Our Case Number: ACP-323930-25

Re: Proposed development will comprise the installation and operation of a Healthcare Waste Treatment and Transfer Facility
Block 8003, Blarney Business Park, Shean Upper, Blarney, County Cork

Subject: TII25-134413 - ACP-PA28.323930 Healthcare Waste Treatment and Transfer Facility Blarney Business Park, County Cork

RE: Healthcare Waste Treatment and Transfer Facility Blarney Business Park, County Cork ACP Reference no PA28.323930.

TITLE: Site Location and Context	
PROJECT: Proposed Healthcare Waste Management Facility Block 8003, Blarney Business Park, Co. Cork	
FIGURE NO: 1.1	
CLIENT: Stericycle	
SCALE: 1:50,000	REVISION: 0
DATE: 16/05/2025	PAGE SIZE: A3

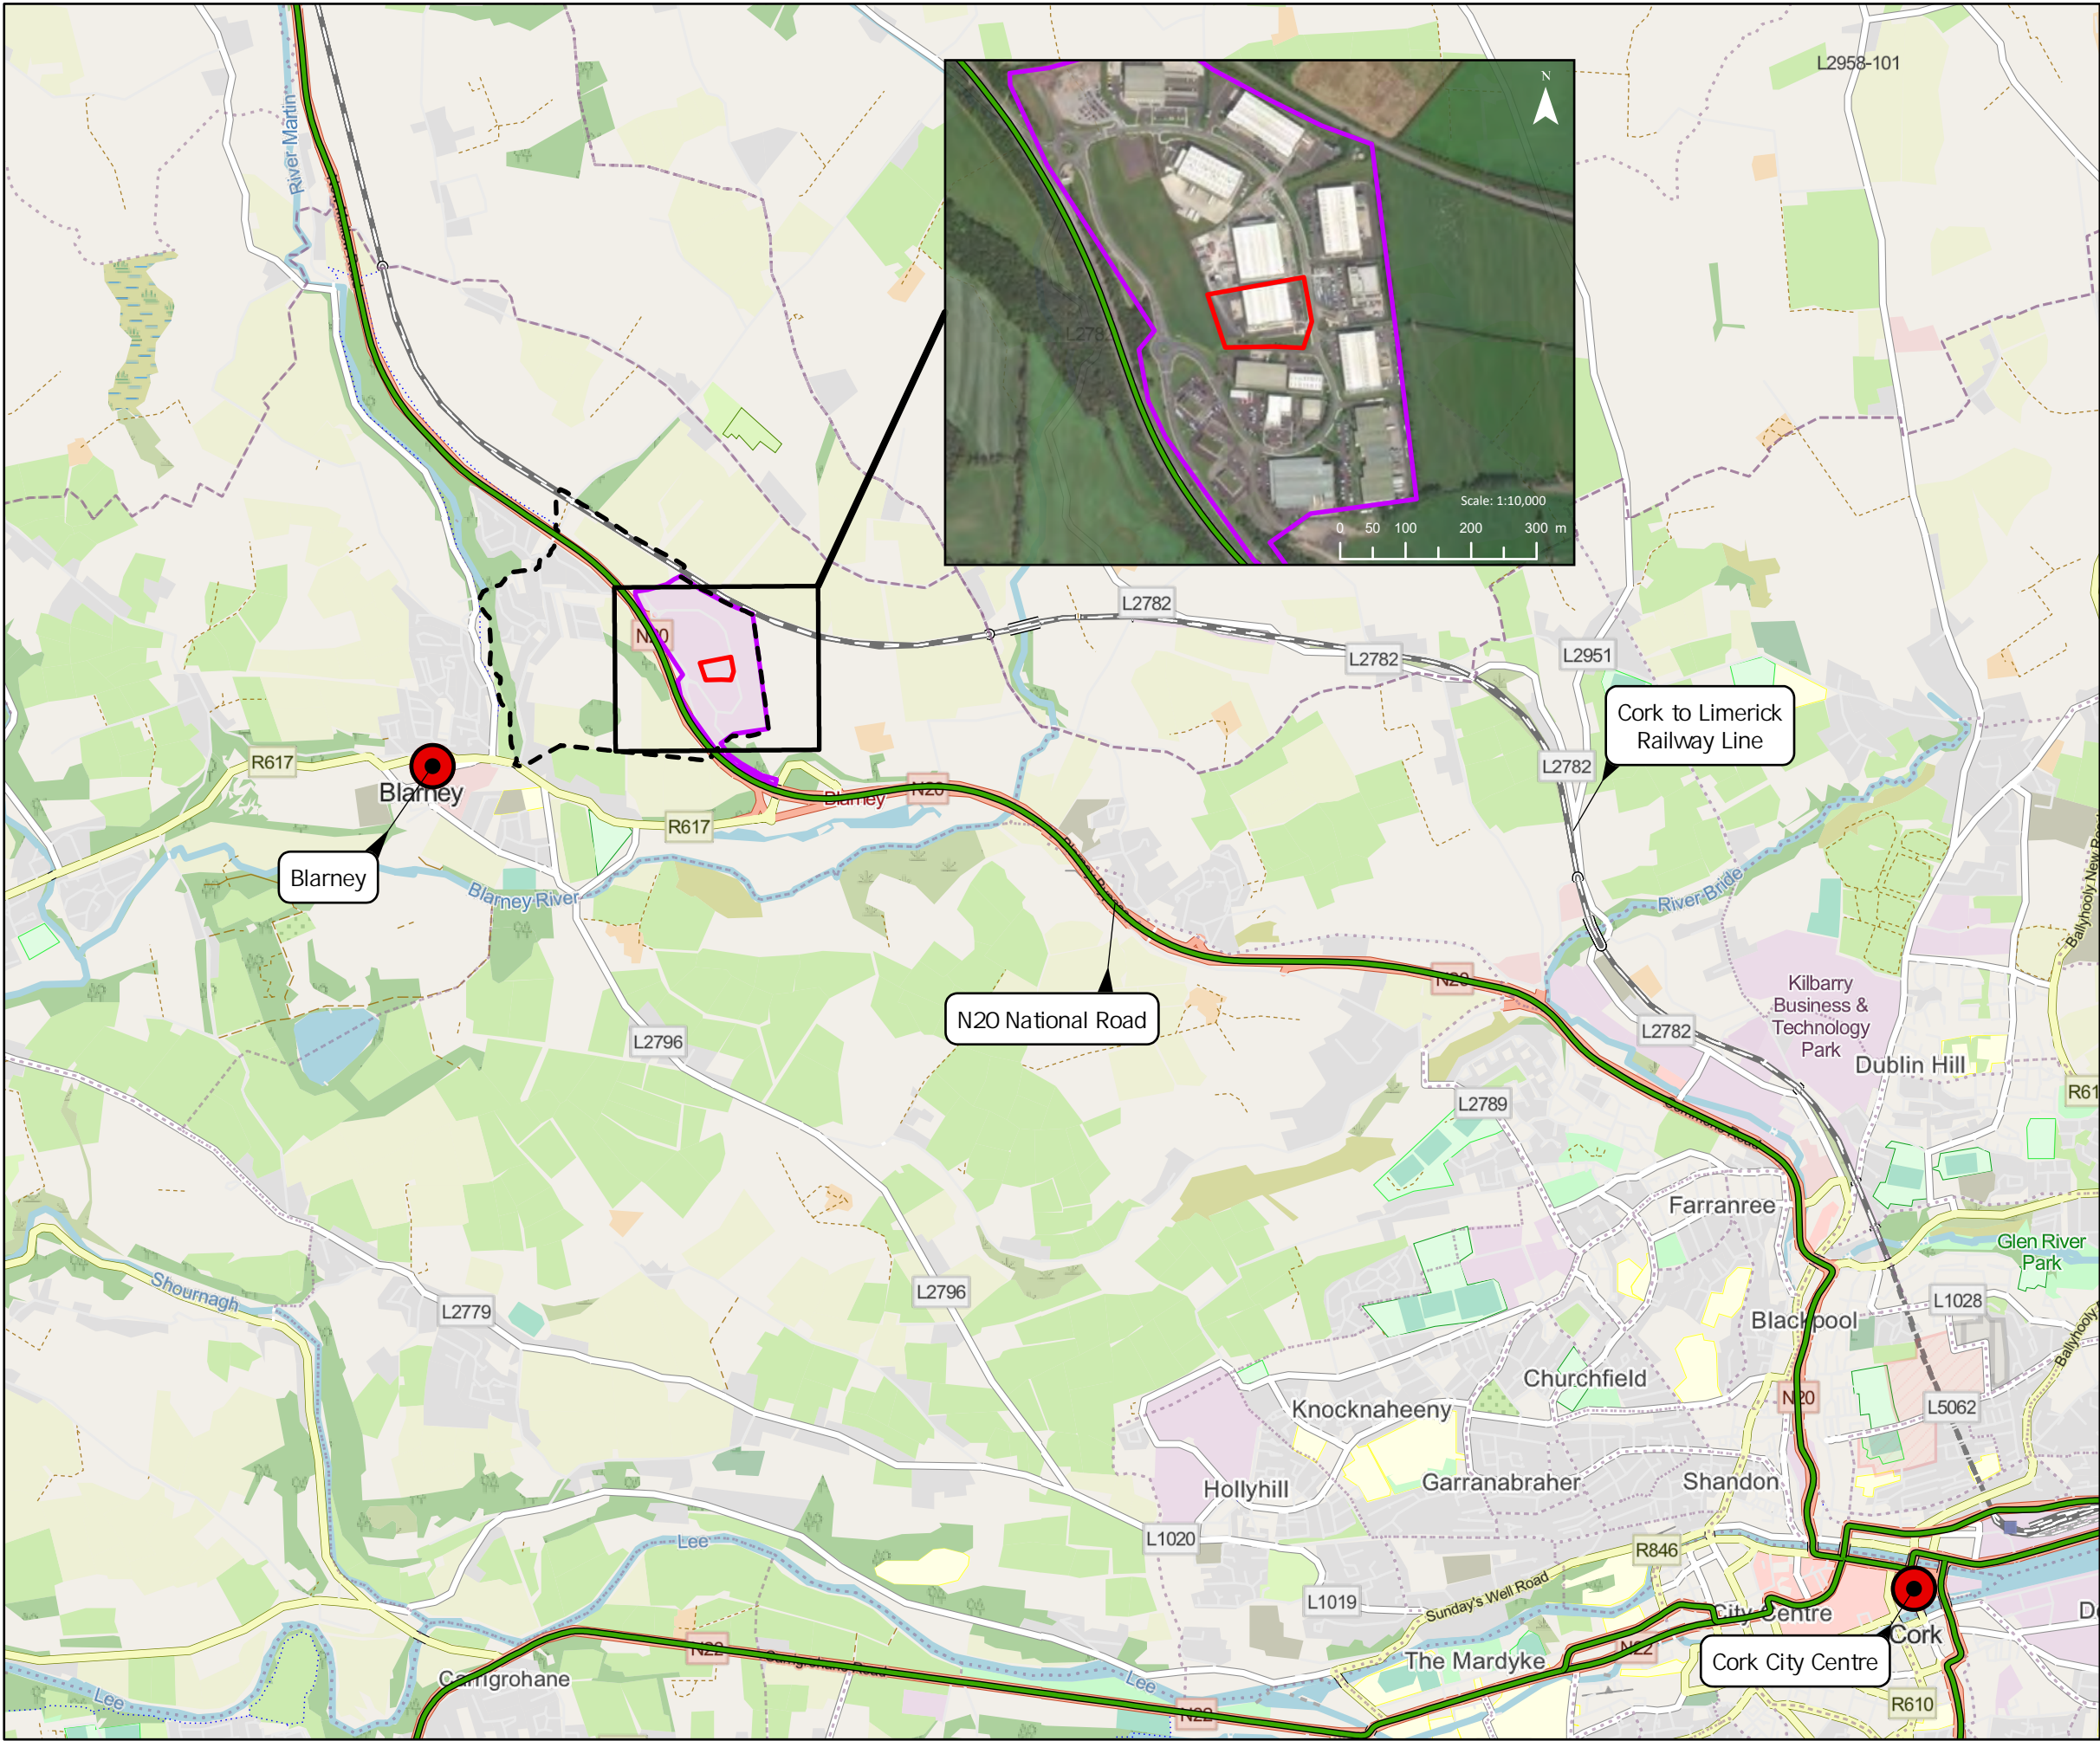
- The proposal is facilitated by a private access direct to the N20 (i.e. non-public road) where a 100kmph speed limit applies. For clarity, the Blarney Business Park access to the N20 and associated road network is not a public road.

- The existing privately owned N20 access which facilitates the proposal is located within an area currently under consideration of a notified and publicly available route option for the N/M20 Cork to Limerick Project national road improvement scheme.

For the Blarney Business Park area, the Update highlights the significant changes in road layout which will be undertaken. These are not reflected in the planning documentation. TII advises that the specific function and road layout of the junction has repercussions for traffic and transport for the planning application proposal at various stages of its delivery and operation. More importantly the Update illustrates the altered public road network which shall exist when

TII advises with concern that the applicant has not taken account of the current scheme updates with proposed future road layout and associated impacts. These matters have significant implications for not only the proposed development, its delivery, operation and also critically the future public road network. Consequently, TII considers no appropriate actions to address and ensure it safeguards the N/M20 Cork to Limerick Project have been identified.

TII advises that the matters raised in this submission require resolution prior to a decision being made on this application . TII advises it would expect that the planning and roads authority Cork City Council would be best placed to assist the applicant, TII and the Commission on these matters .
